## **OXFORDSHIRE COUNTY COUNCIL'S RESPONSE TO CONSULTATION ON THE FOLLOWING DEVELOPMENT PROPOSAL**

**Application no:** 21/02286/F

**Proposal:** Construction of a coffee unit with drive-thru facility and indoor seating with associated access, car parking, landscaping and servicing parking

**Location:** Land North West Of Launton Road Roundabout Adjoining, Skimmingdish Lane, Caversfield

| Drawing Title | Location Plan | | | |

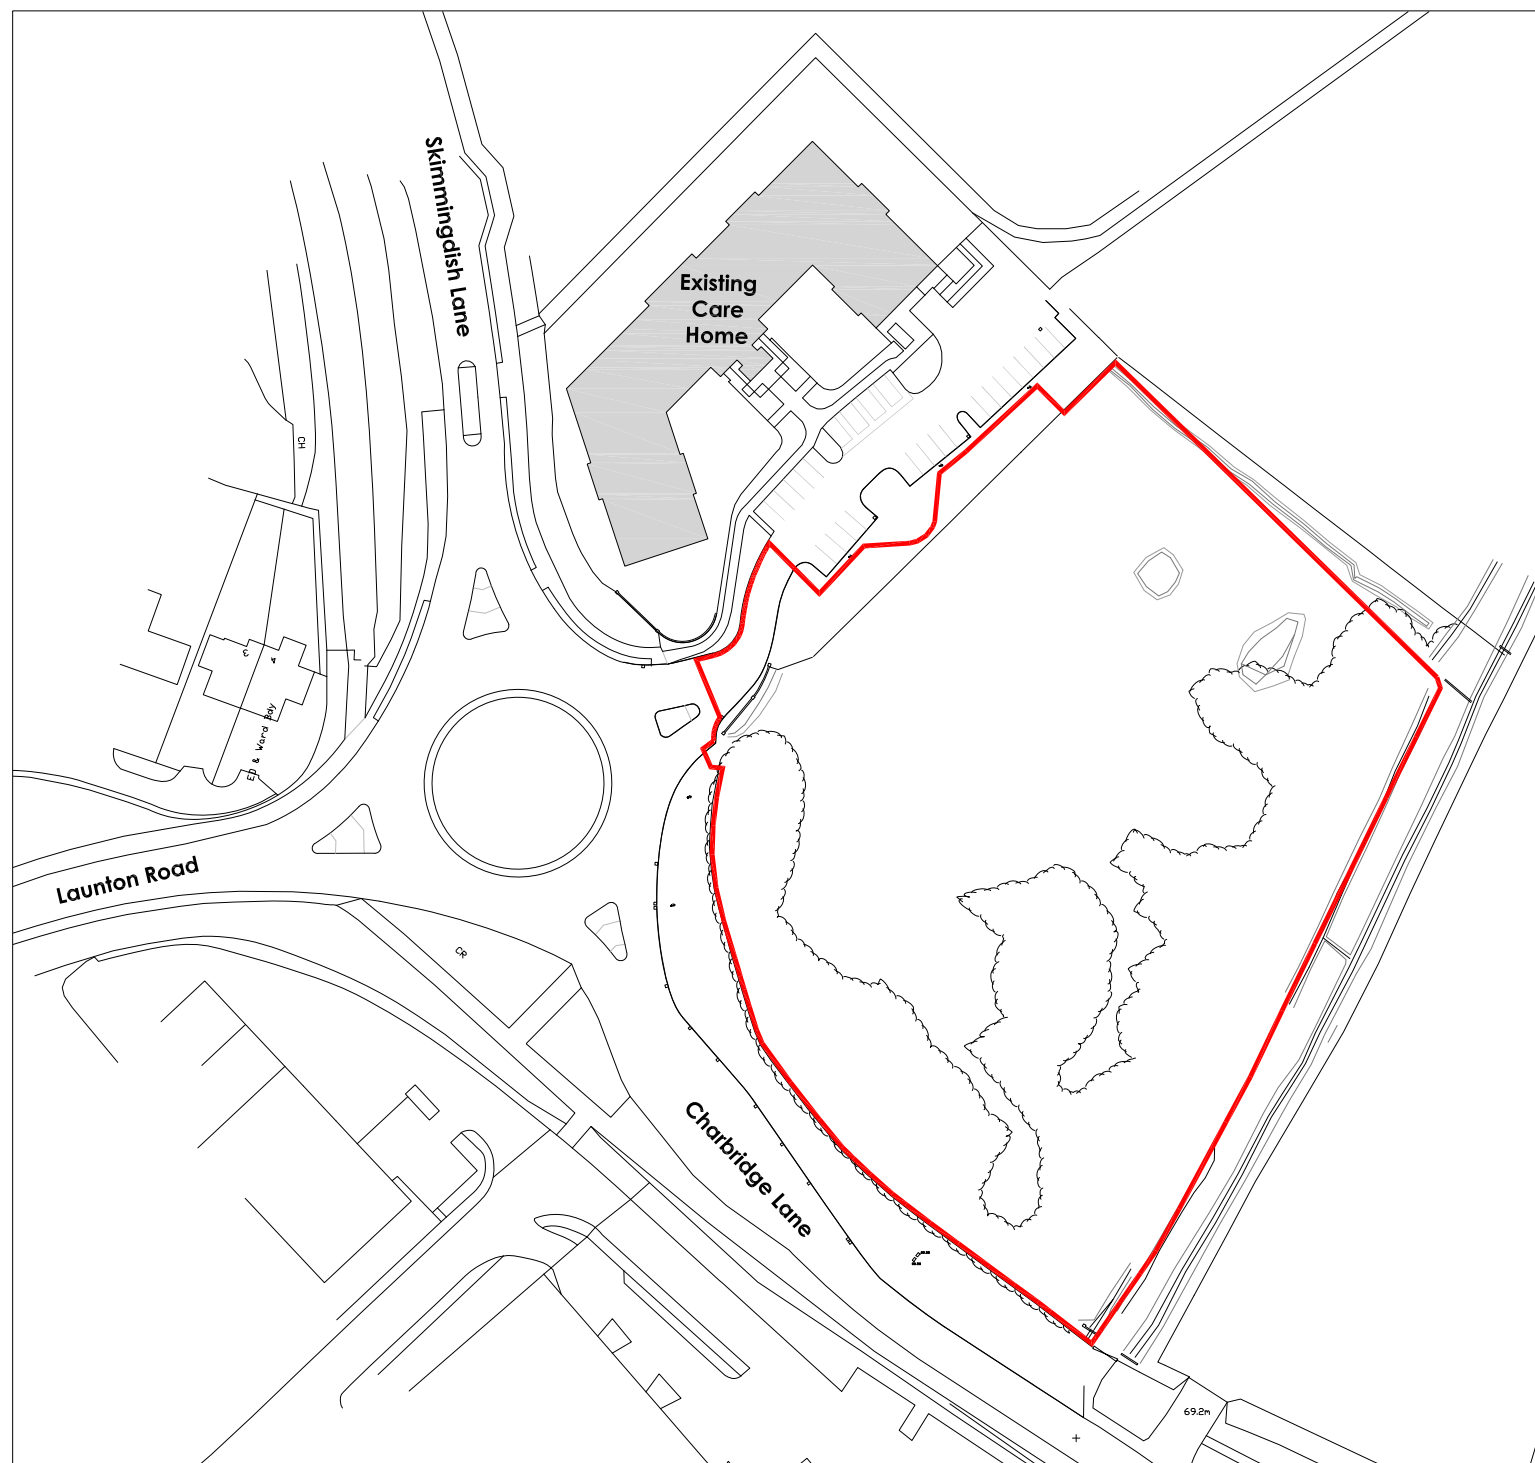
Regarding the drive-thru development, it is noted the redline extends to the farm track. It would therefore be good to get a connection for footpath 272/16 through the site just so it does not dead end. Two suggested alignments are shown on the map below. Although officially a dead end, walkers regularly red line. To prevent this, it would be good to see this dedicated as a PROW, which would include some clearance and surfacing works,

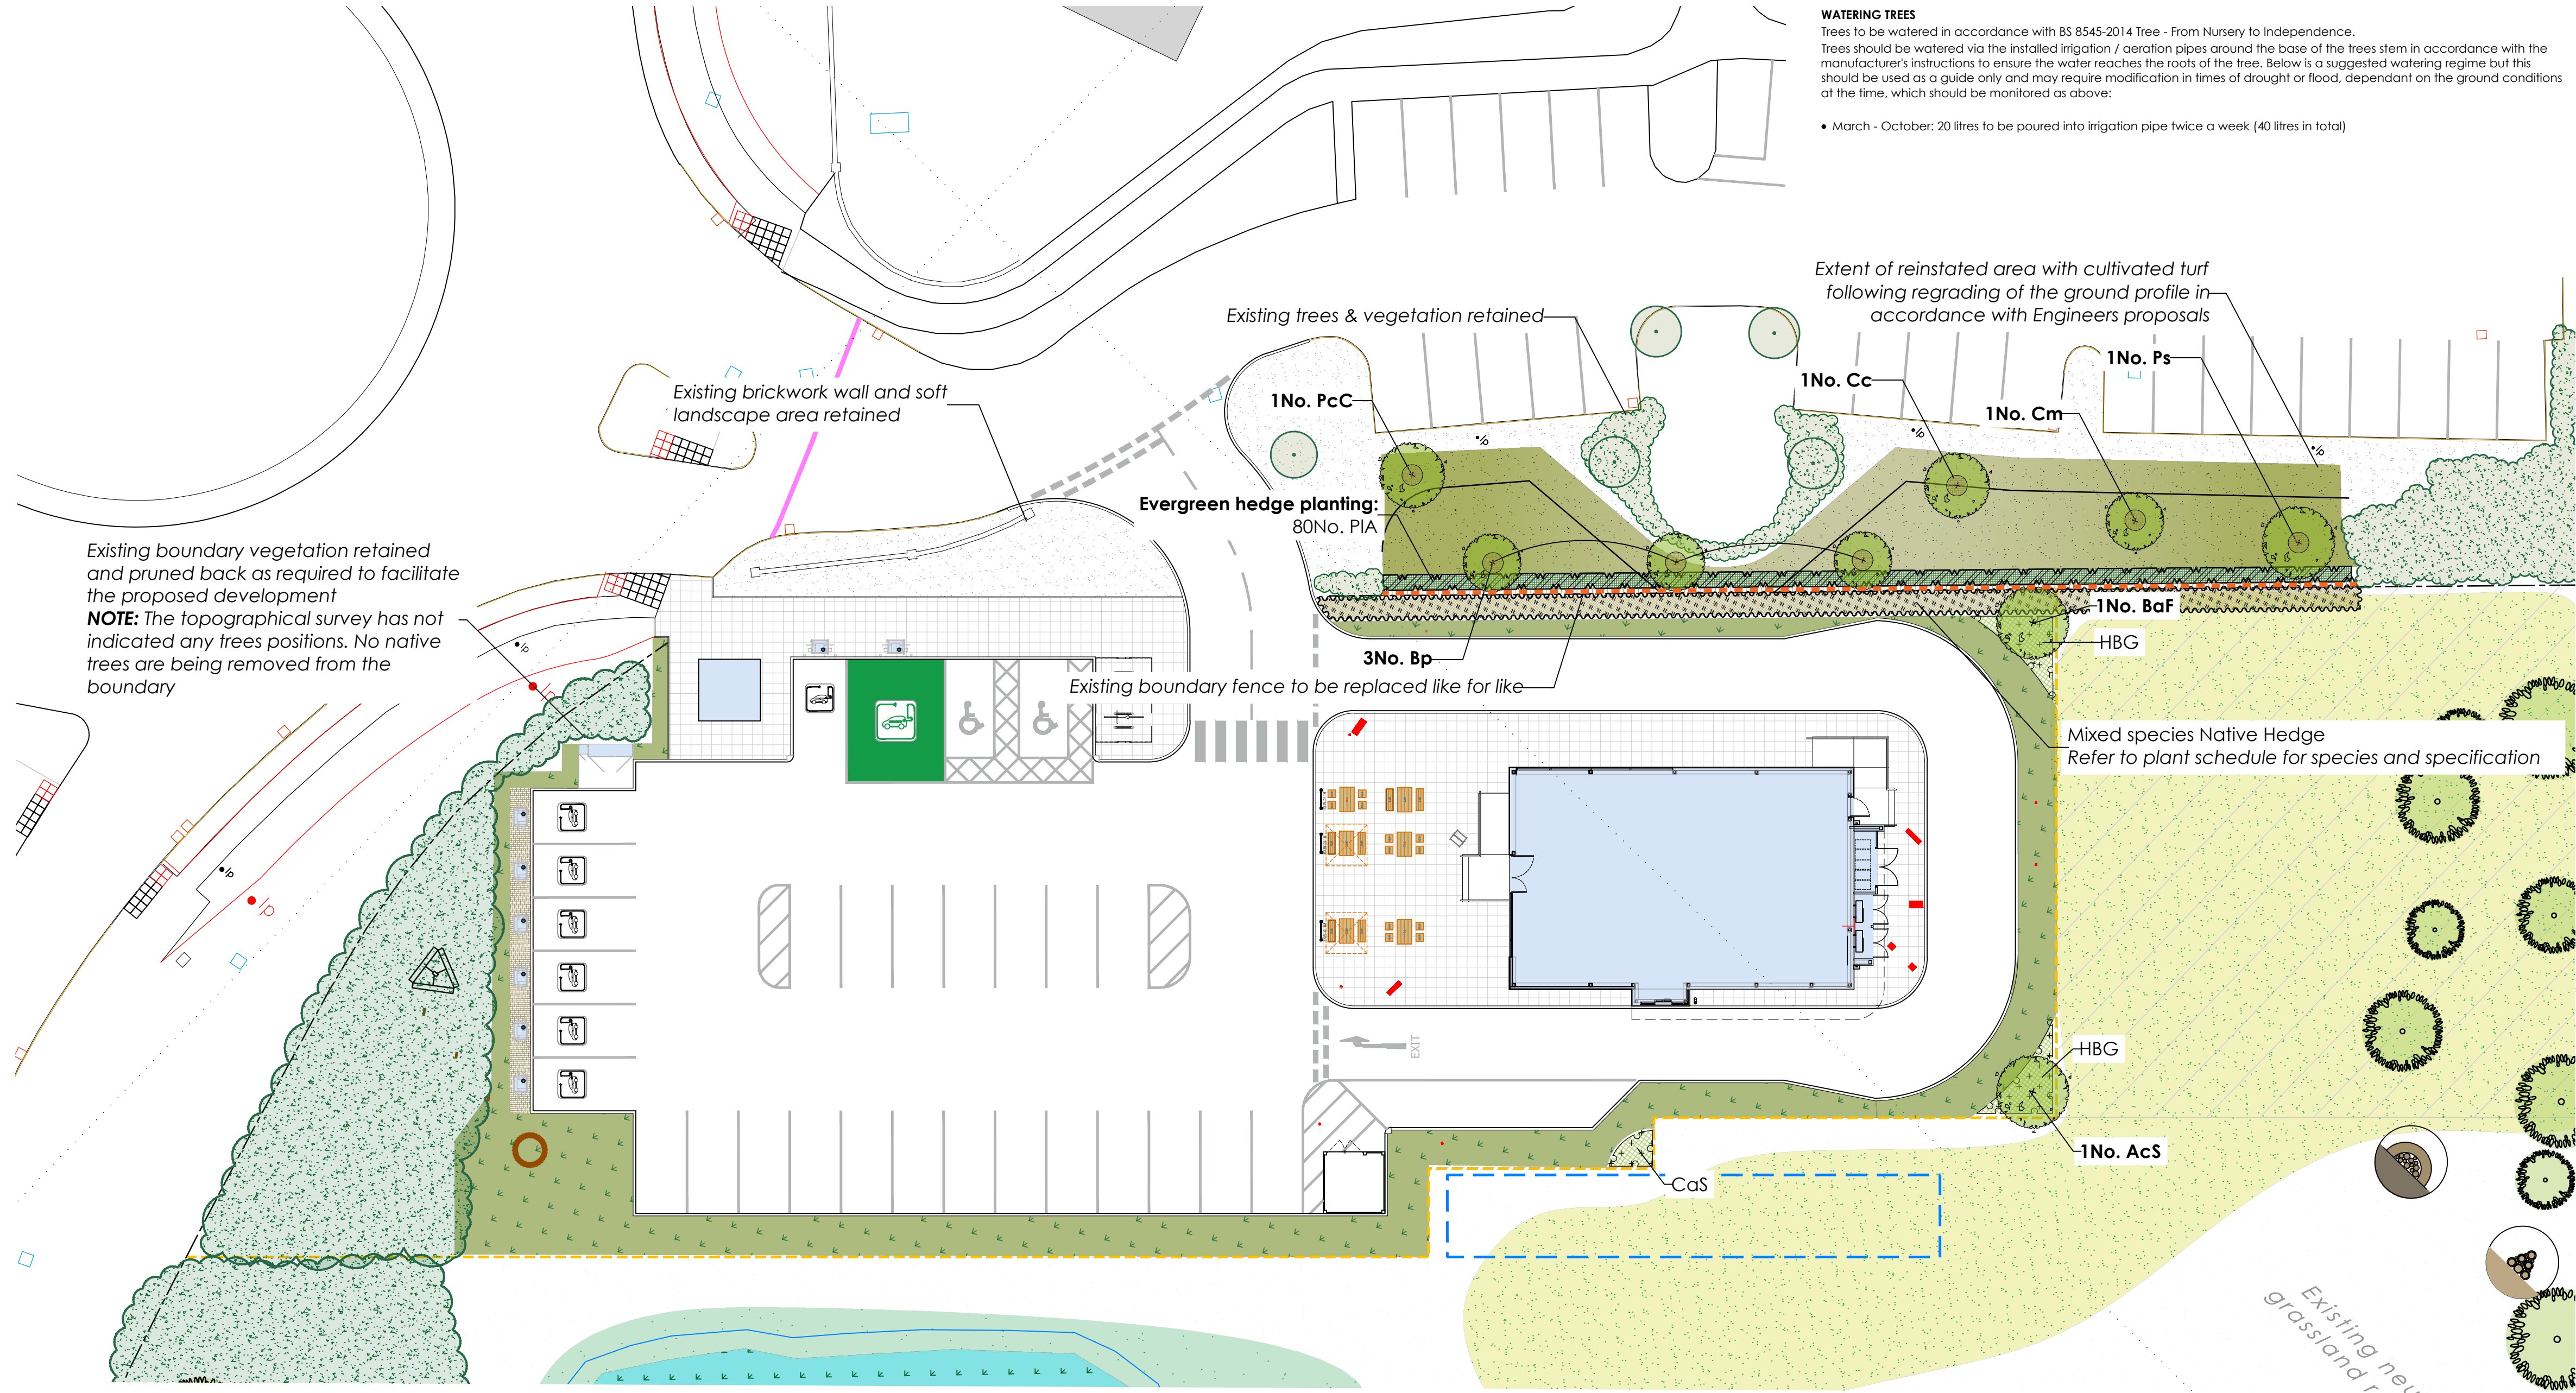
A total of three covered Sheffield stands will be provided in total six spaces for staff and customers. In my view this should be doubled as a minimum to encourage active travel by patrons.

The current location of the cycle parking within the car park could be a deterrent for cyclists (especially staff members who maybe leaving their bicycles for a significant period) - a) it is situated at the furthest edge of the car park, a fair distance from the main building and, b) is not in a visible location and so the security of the bikes may become an issue. It is therefore recommended for the cycle parking to be moved closer to the main building.
